An
Bord
Pleanála

Board Direction
BD-007069-20
ABP-308002-20

The Board decided to grant permission generally in accordance with the Inspector's recommendation, for the following reasons and considerations, and subject to the following conditions.

PROPOSED MIX OF DOUBLE STACKER CYCLE PARKING SYSTEM AND STANDARD SINGLE LEVEL CYCLE PARKING

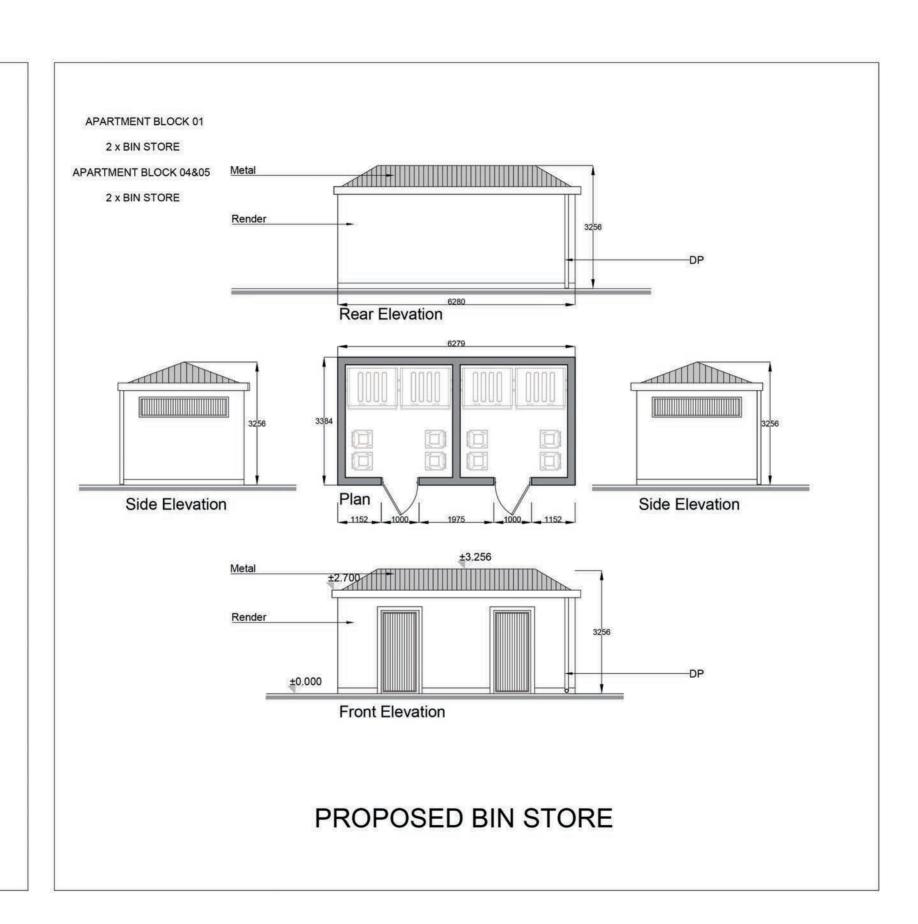
12. The number of bicycle parking spaces within the site, shall be agreed in writing with the planning authority. Details of the layout, storage arrangement, marking demarcation, and security provisions for bicycle spaces shall be submitted for the written agreement of the planning authority prior to commencement of development.

**Wall Type 1**  
1:50

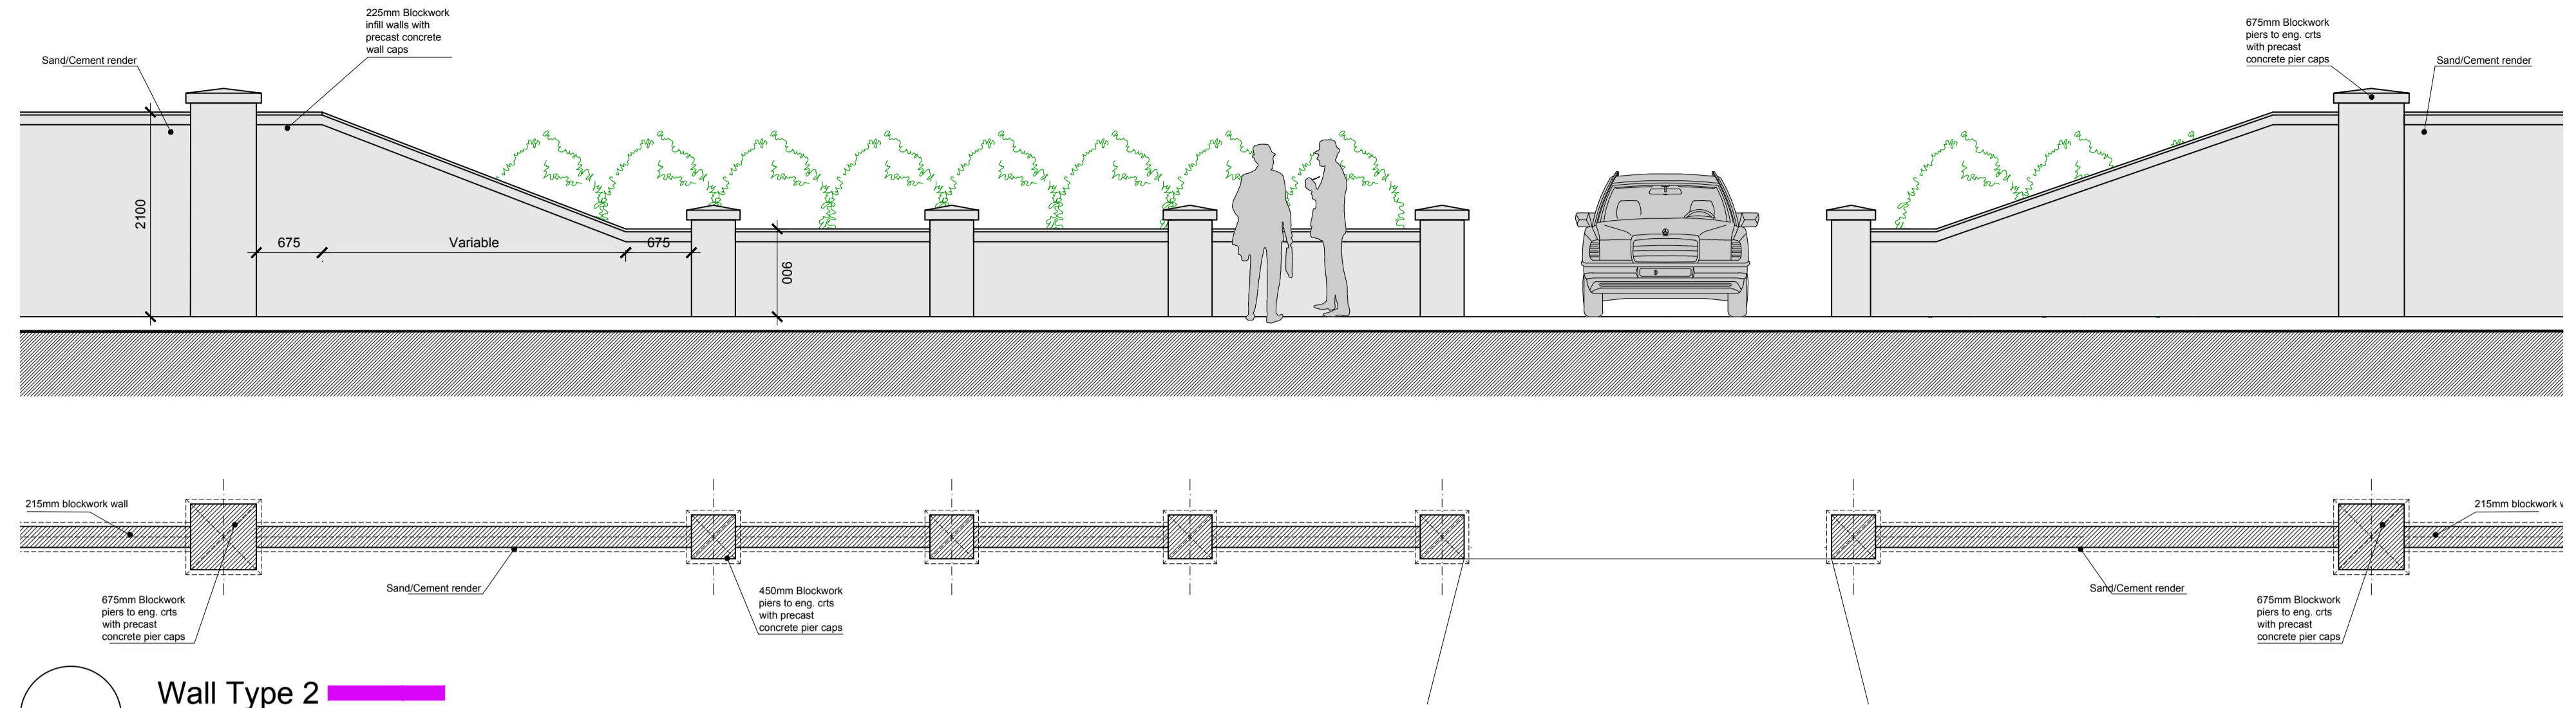
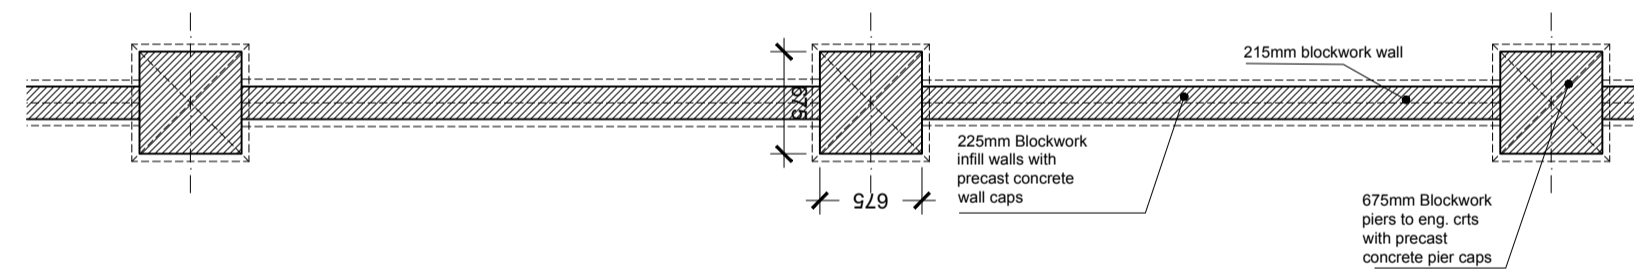
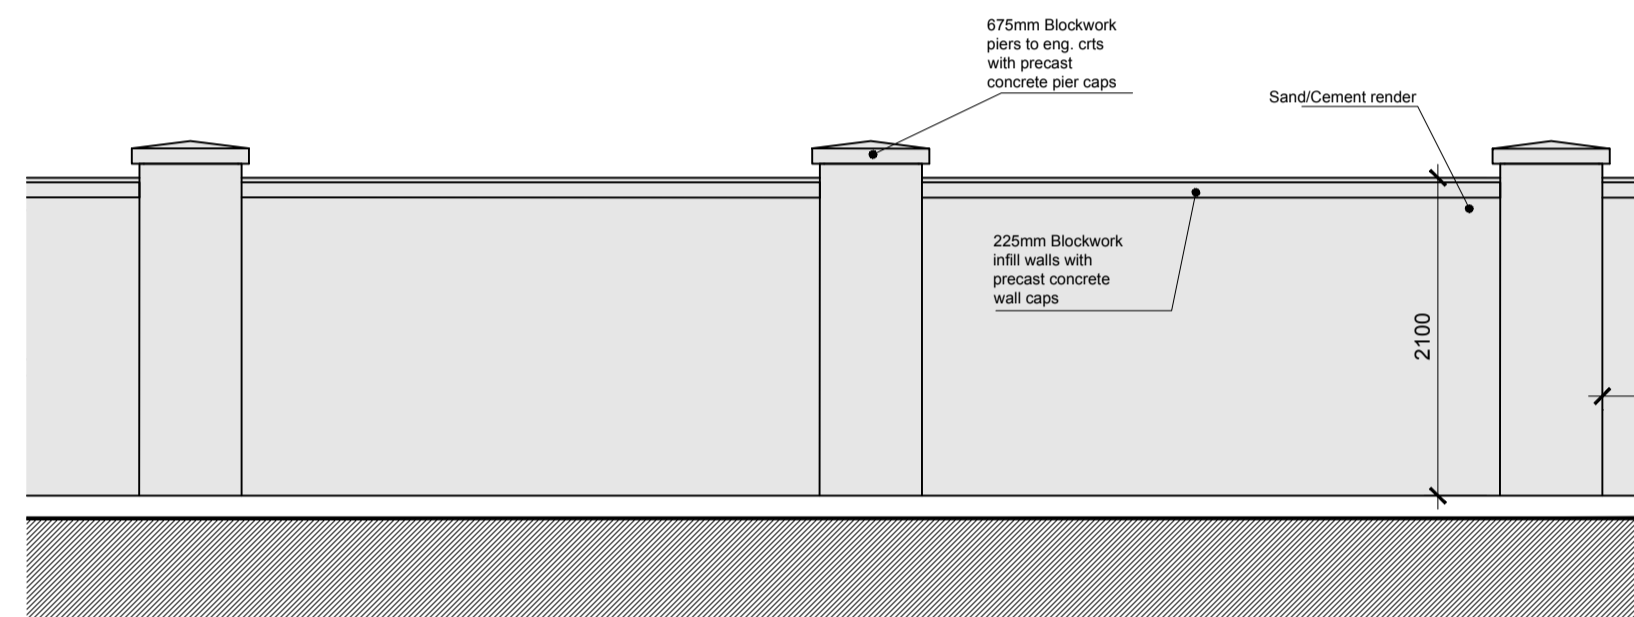
- (g) Wall Type 1 to the front of dwelling numbers A1/14-01 to A1/18-18 to the west of the site and the front boundary Wall Type 1 to all other dwelling houses facing toward the estuary along the northern and eastern boundaries, shall be replaced with 900-millimetre-high railings supported by planting;

**Wall Type 2bis**  
1:50

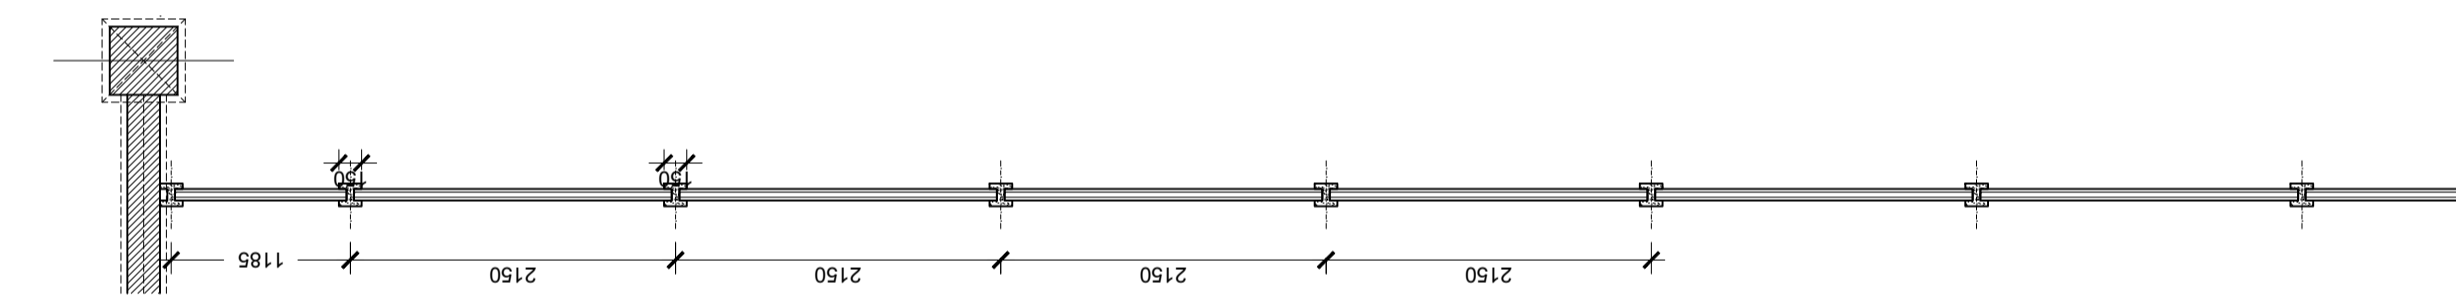
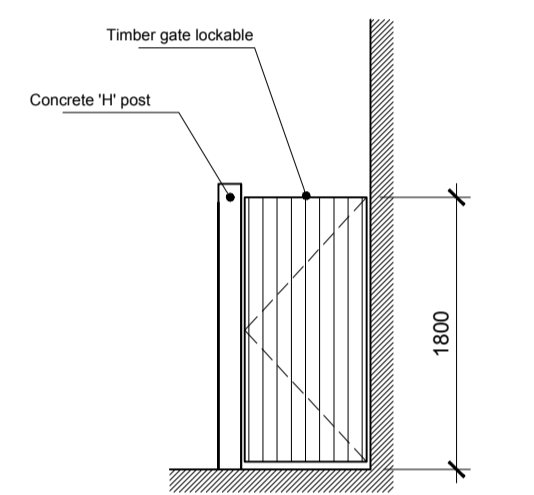
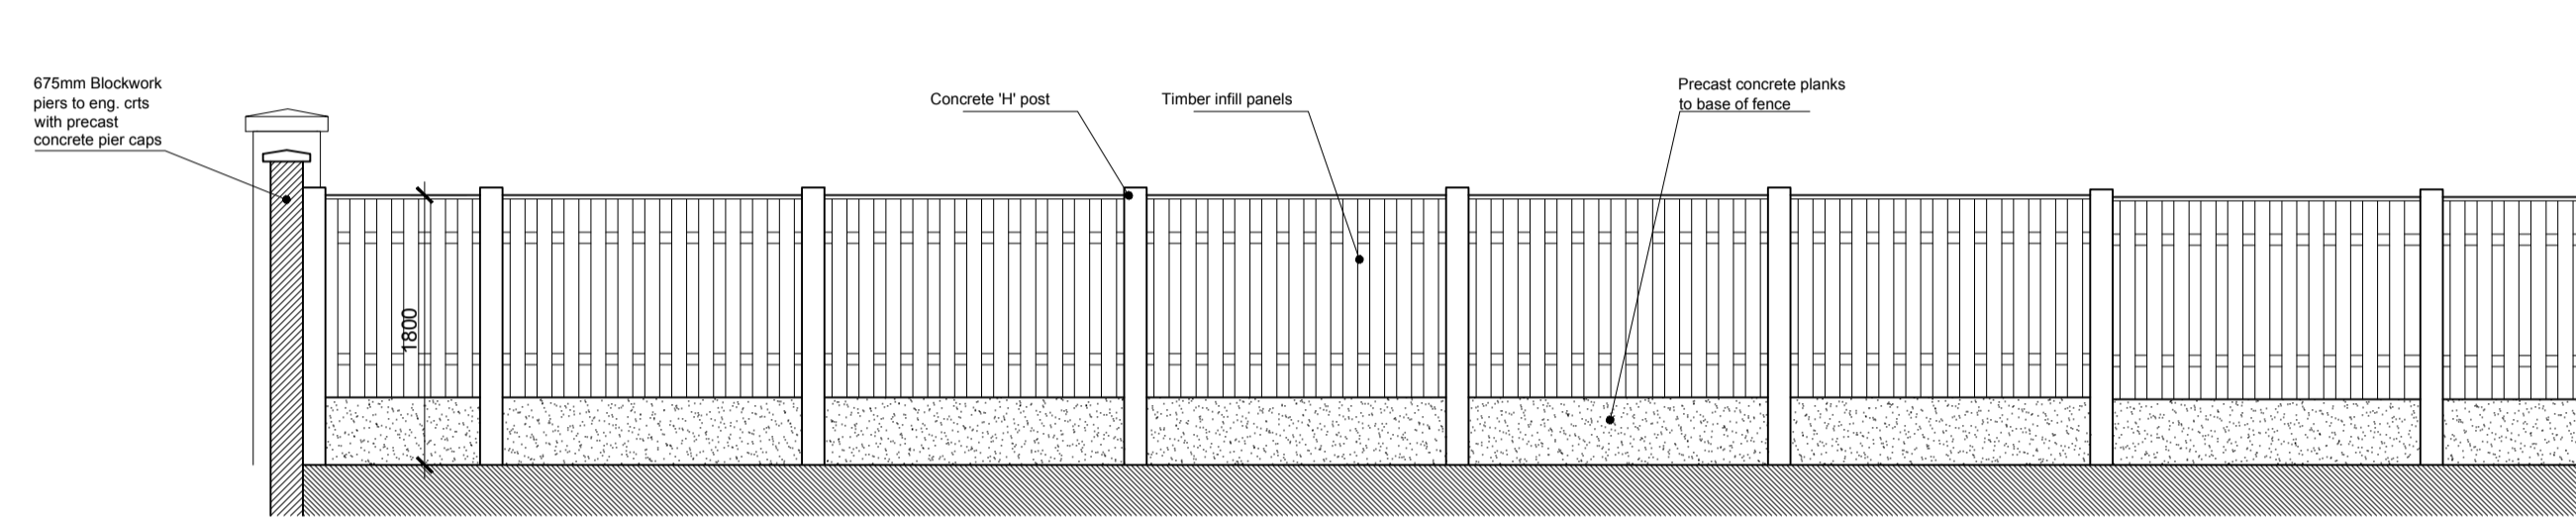
- (e) Wall Type 2 and Wall Type 2bis shall have an overall maximum height of 2 metres;
- (f) Where Wall Type 2 is proposed, the lower height of 900 millimetre shall apply to the entire depth of the main two storey elevation of the dwelling to which it relates and the wall shall only increase in height to 2 metre along that section of the boundary that relates to the rear garden behind the two-storey element of the building;

- (h) The side boundary Wall Type 2bis to the side elevation of dwelling unit numbers A1/14-18 shall be replaced with Wall Type 2;
- (i) Dwellings on plot numbers C1/7-03, C3/7-04, C3/7-5, C1/7-06, shall be omitted and replacement dwellings designed to provide an elevation to the street to the east as well as to the north and south, with dual frontage units at the corners;
